Permit Number: 071288

has permission to Change of use w/ tenant fit-out from Multi-Family to 2 Family

AT 11 DEERING ST PORTLAND, OR 97201 046 B022001

Dept: Building **Status:** Approved with Conditions **Reviewer:** Chris Hanson **Approval Date:** 12/10/2007

Third Floor Plan
 1/4" = 1' - 0"

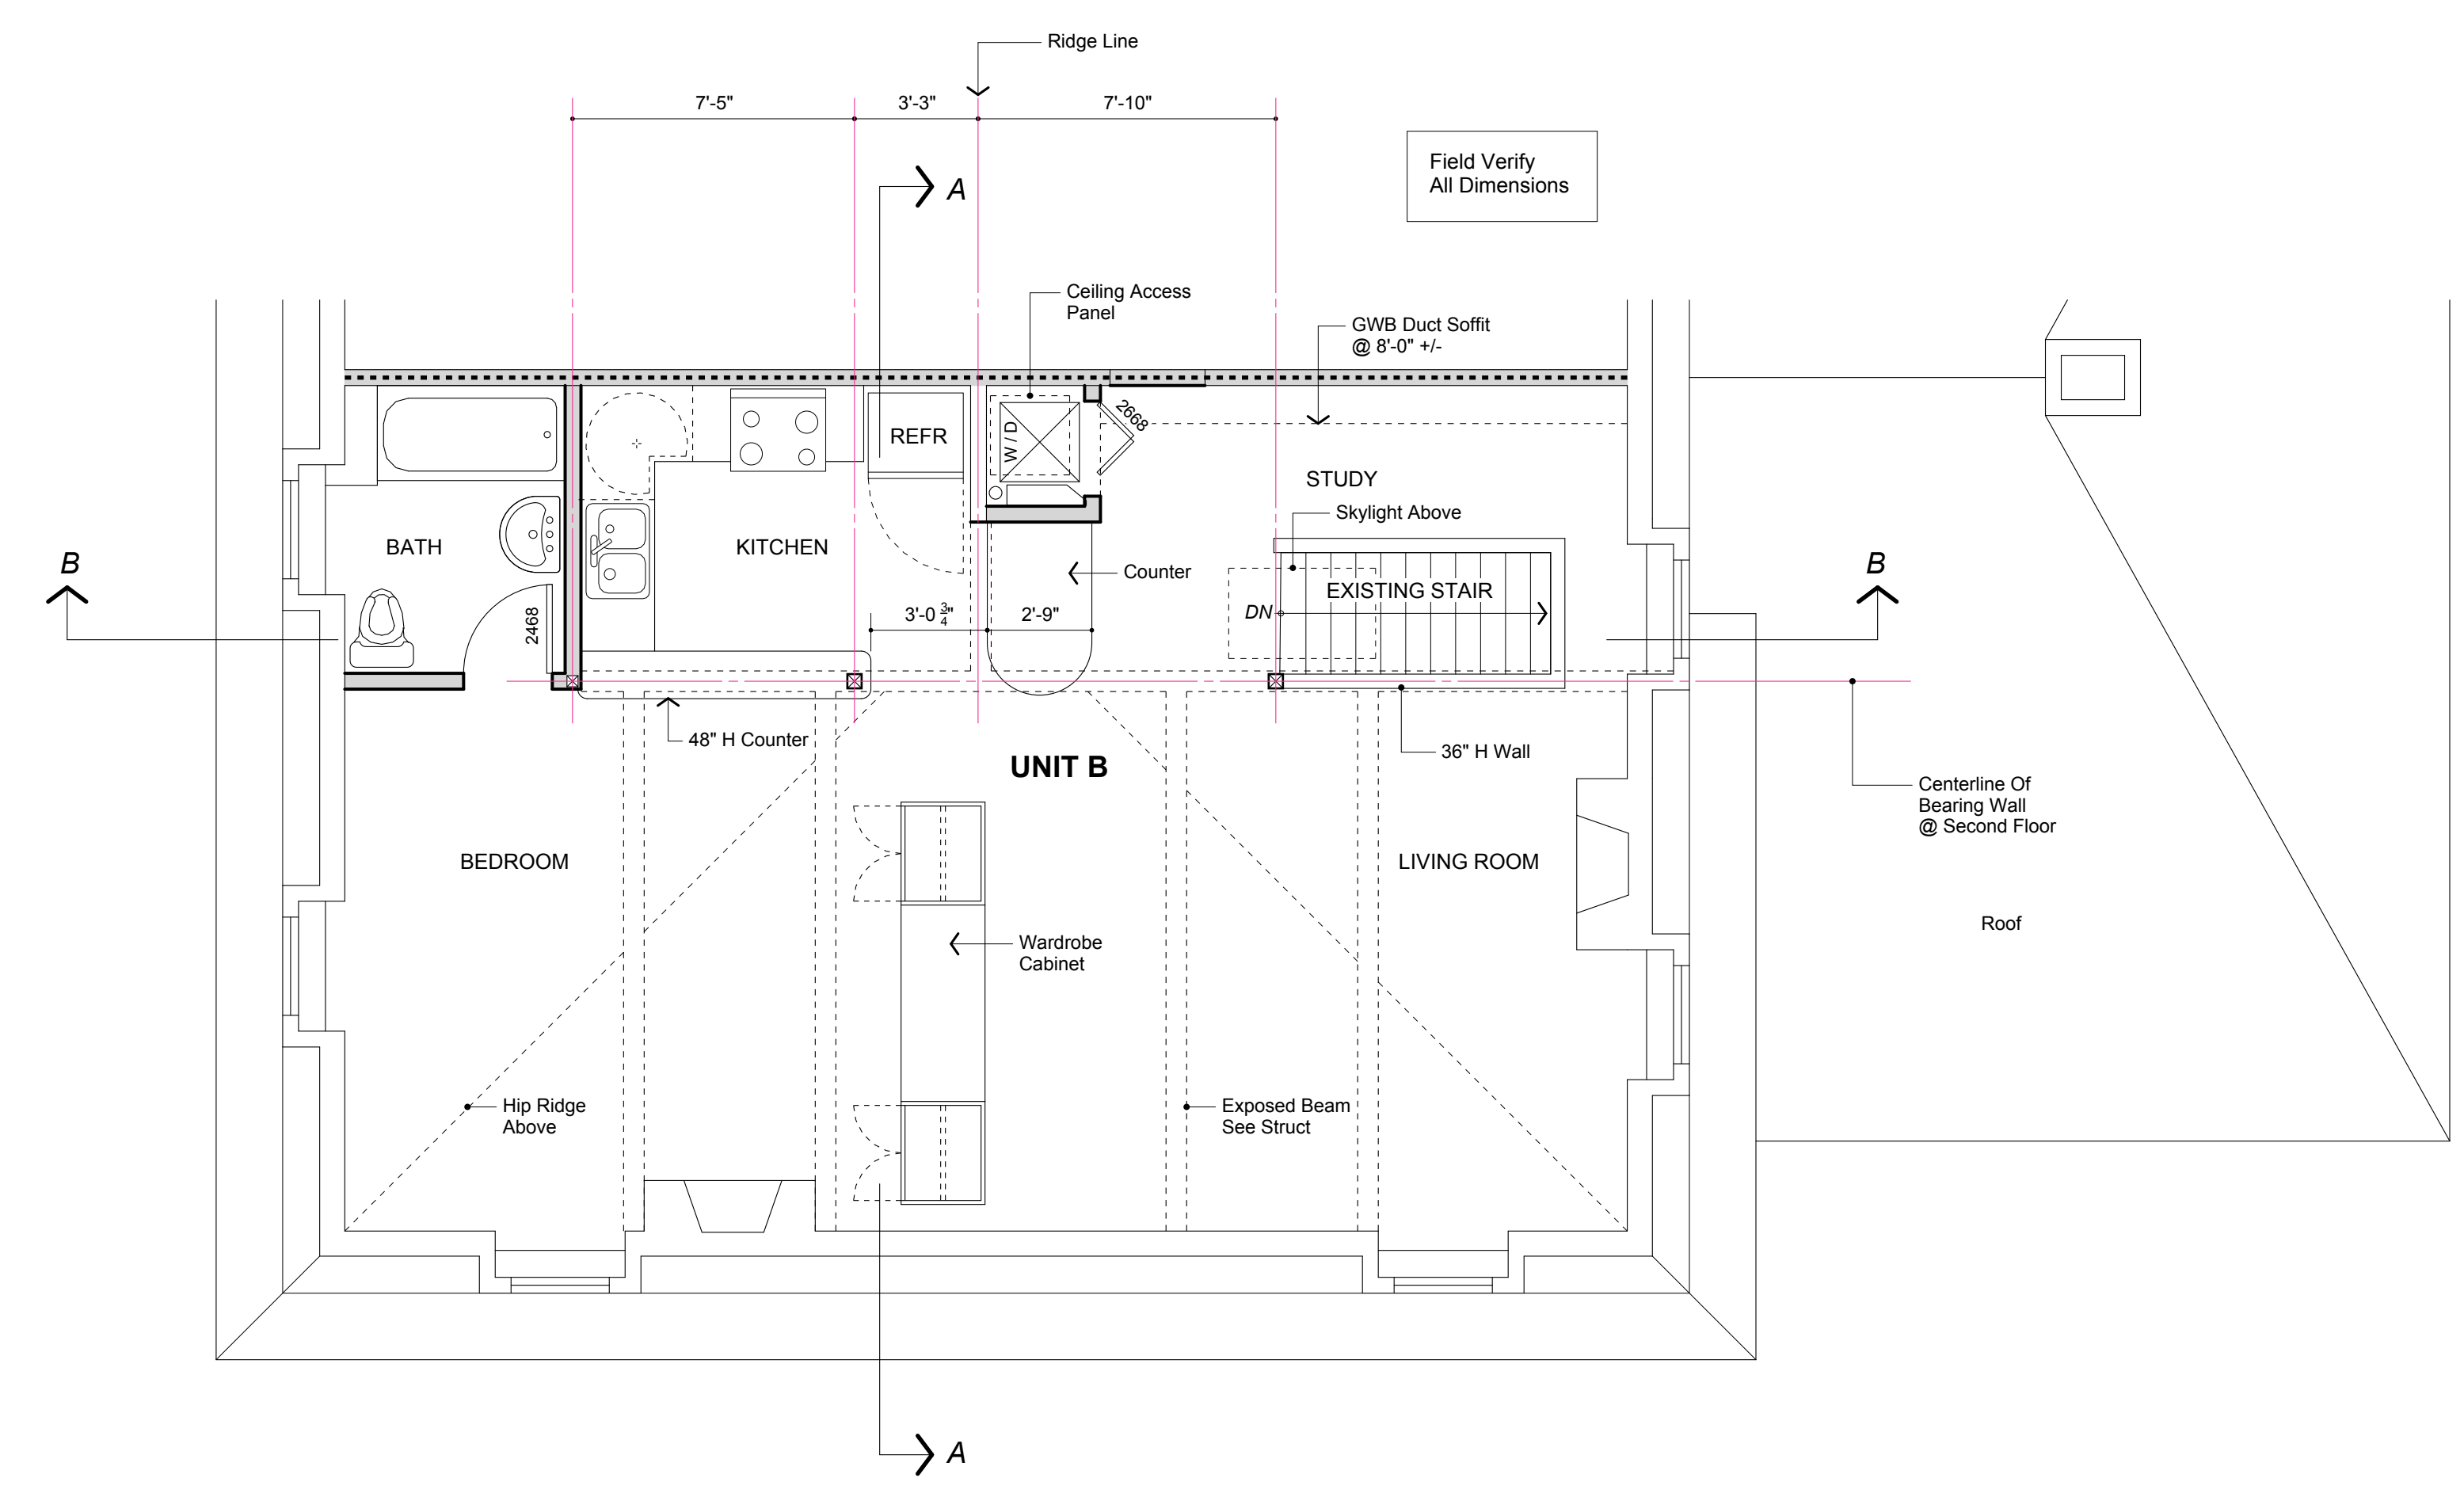
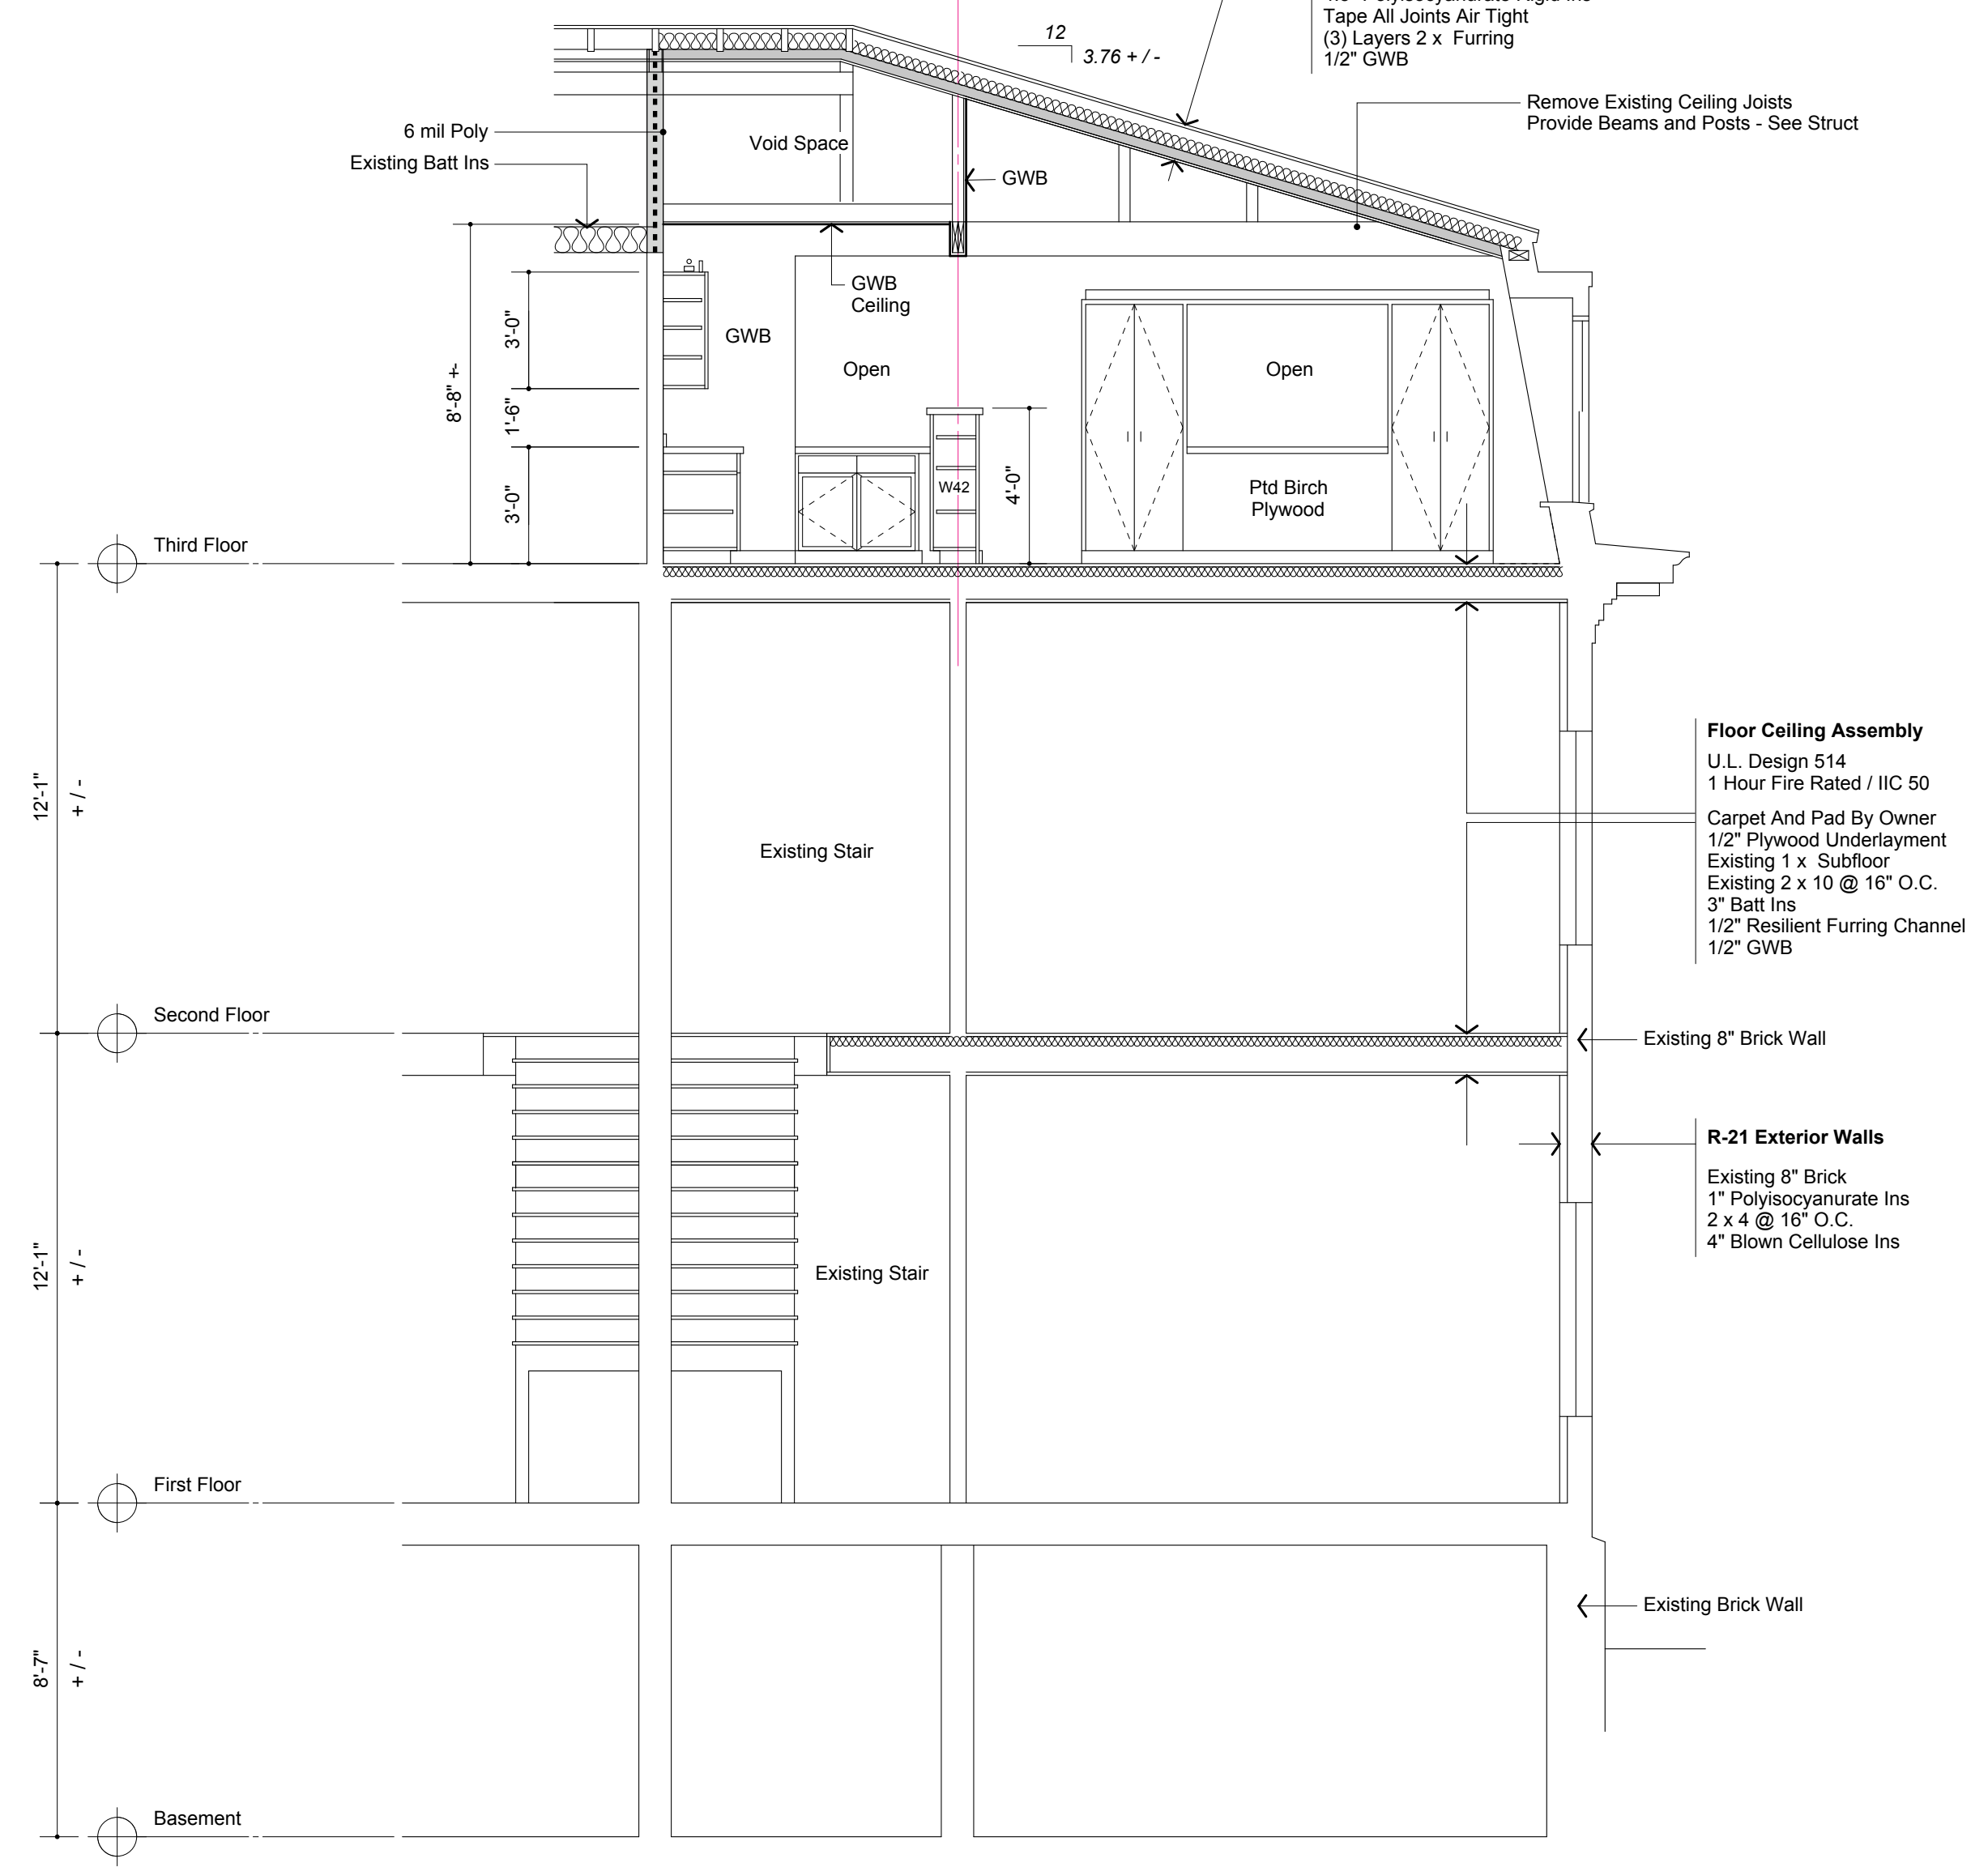
- 1) This permit is being approved on the conition that the seperation of 11 and 13 will be an approved UL listed assembly as req. For a 2 hour seperation.

- 2) All bedrooms shall have at least one code compliant egress window
- 3) prior to close -in a U.L. Listed 2 hour demising wall must be approved by this office Chris Hanson

- 10 All penetrations between dwelling units and dwelling units and common areas shall be protected with approved firestop materials, and recessed lighting/vent fixtures shall not reduce the (1 hour) required rating.
